# Rezoning Transportation Analysis

Petition Number: #2022-090

General Location Identifier: 02529122

Date	Description
11-28-22	First Review (TM)
01-25-23	Second Review (TM)

RZ1.00

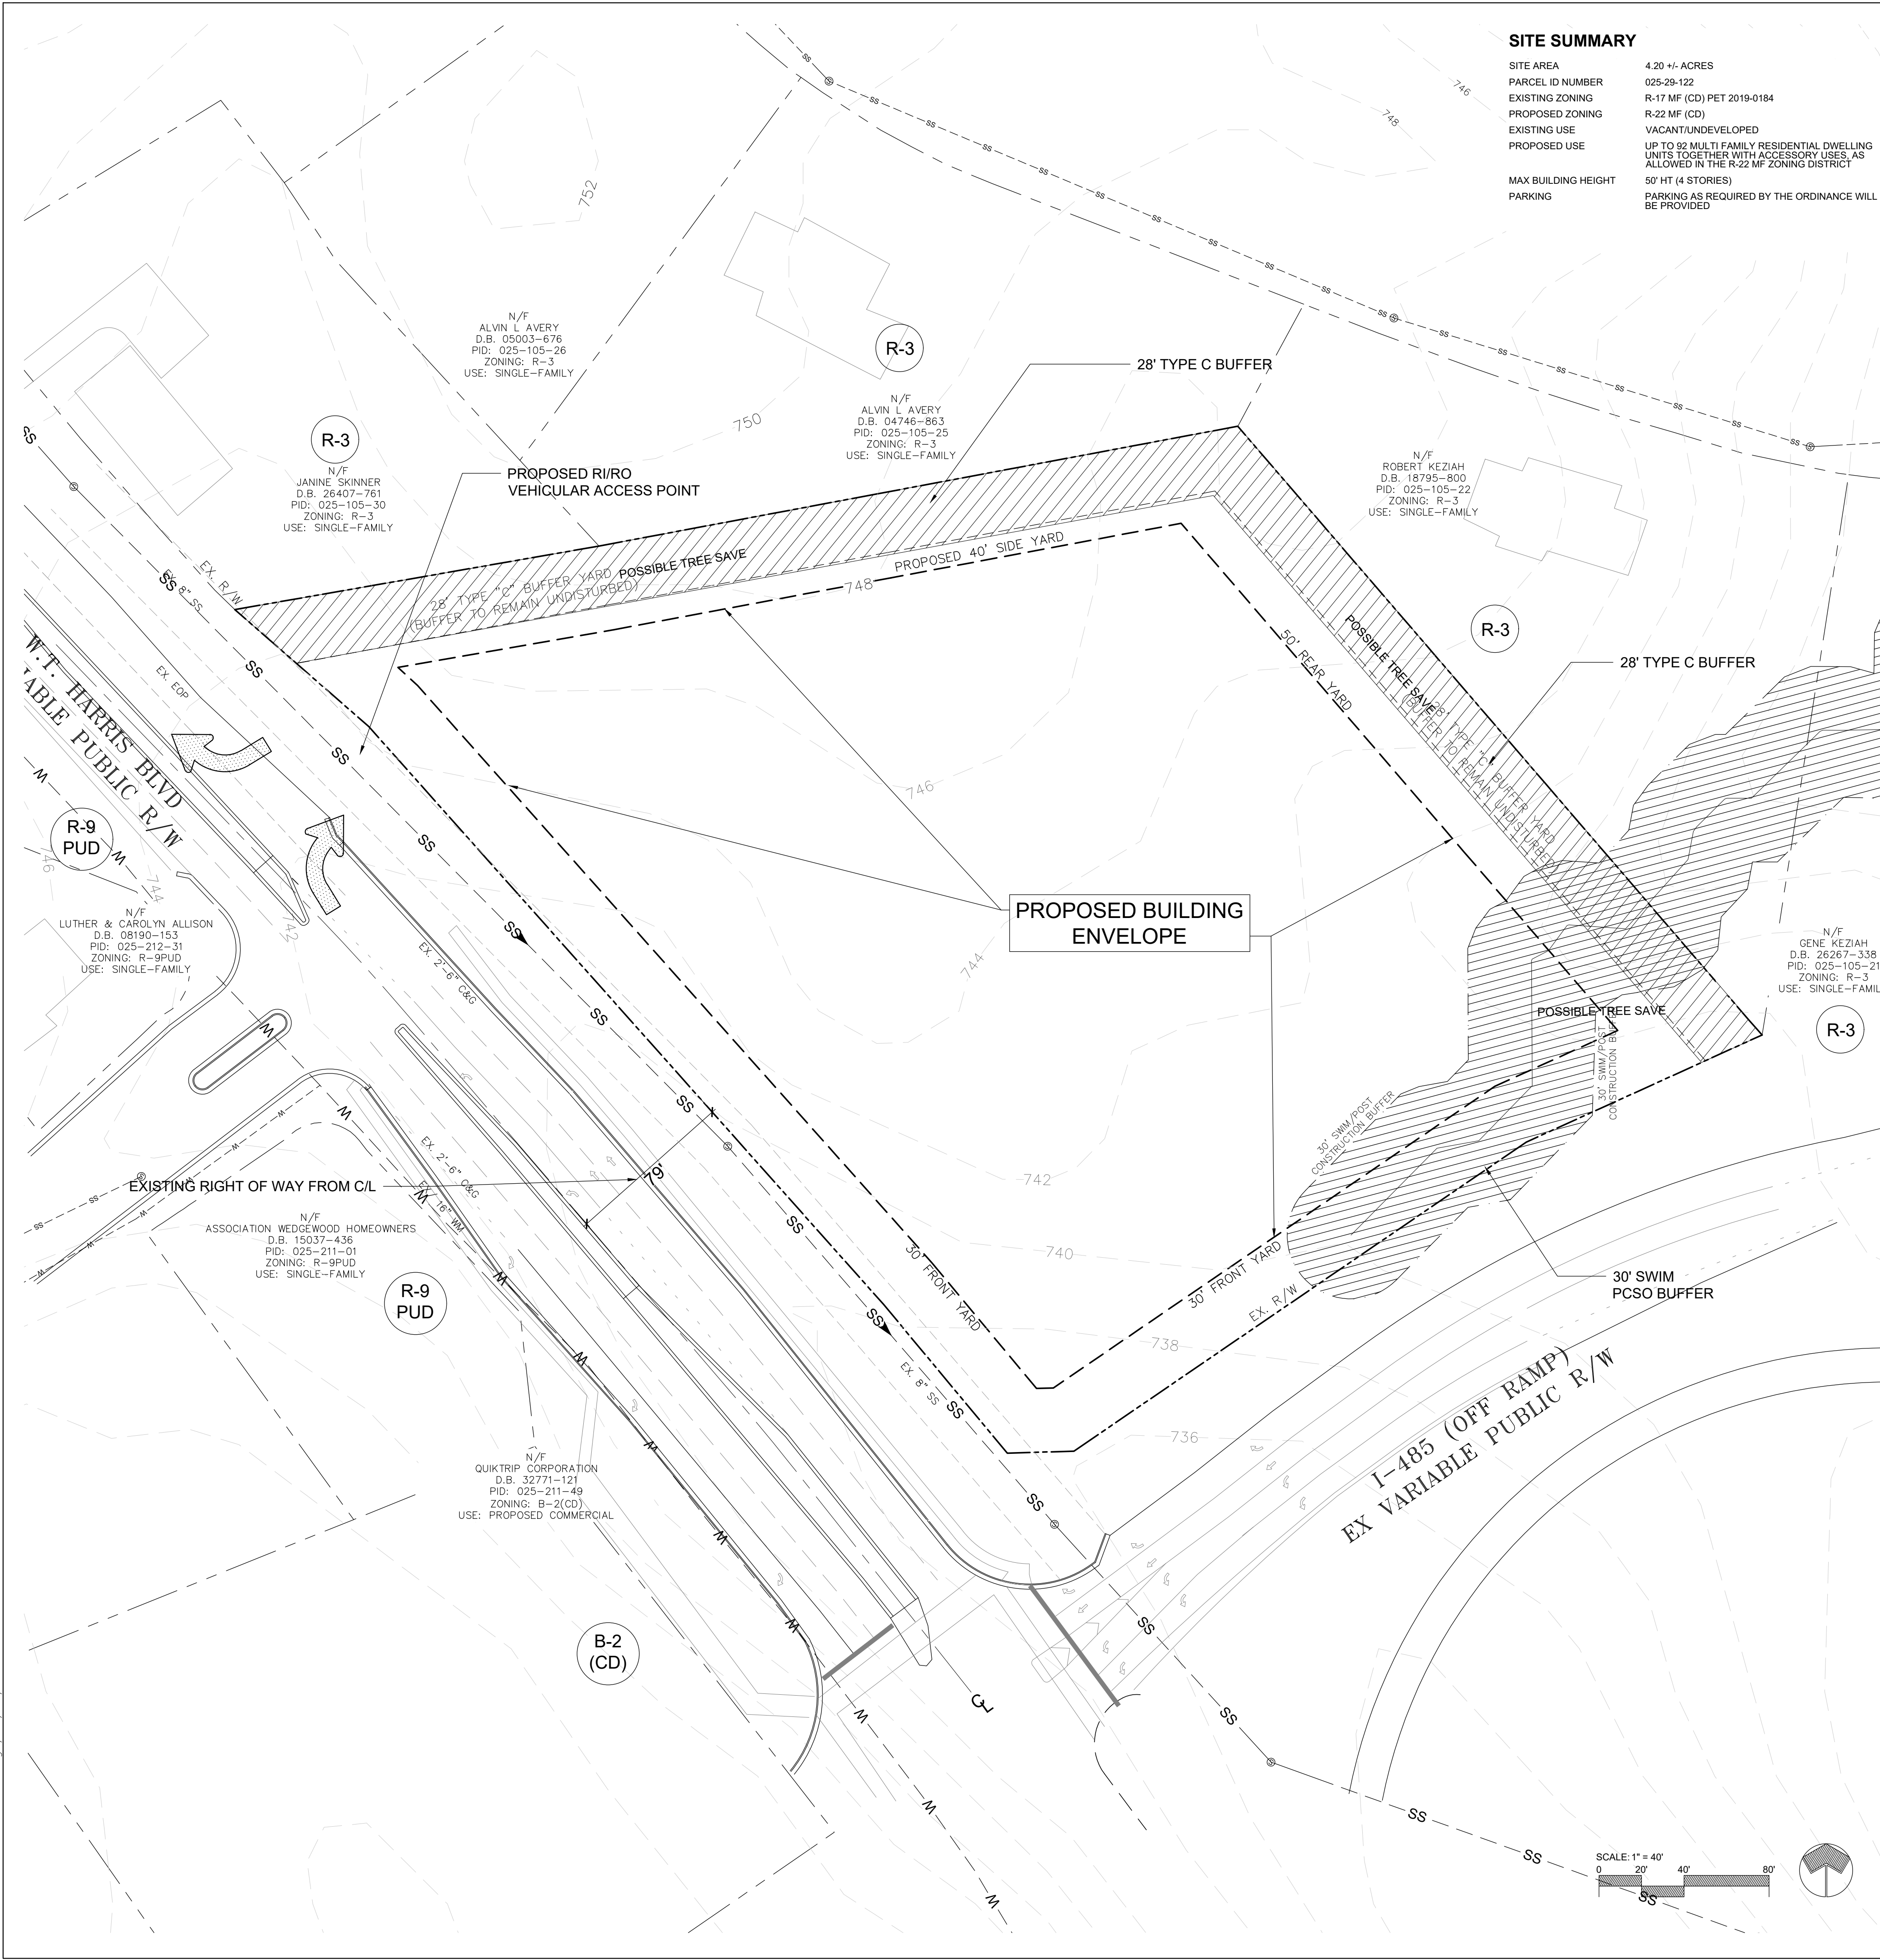
4. Site plan and conditional note(s) revisions are needed to commit to construct curb and gutter from existing curb and gutter to the Northern property line of the site. Curb and gutter shall be labeled and dimensioned from the centerline of WT Harris Boulevard on the site plan.

**Clarifying Comment (01-25-23):** label and dimension curb and gutter on the site plan.

7. **Outstanding Comment from 11-28-22:** Revise site plan and conditional note(s) to provide a 100-foot driveway stem measured from the proposed right-of-way. Site plan shall dimension this from the proposed right-of-way.

**Clarifying Comment (01-25-23):** Driveway stem is measured from proposed right-of-way. Site plan revisions are needed to show a internal driveway stem from the right of way line

9. A site plan note specifying that all transportation improvements will be approved and constructed before the site's first building certificate of occupancy is issued as needed. The petitioner may phase transportation improvements if said improvements and phasing are explicitly described in site plan notes.

Remove existing conditional note 3D.

11. **New Comment 01-26-23:** Proposed change in access location requires further additional discussion with NCDOT. CDOT to coordinate directly with NCDOT on proposed access location.
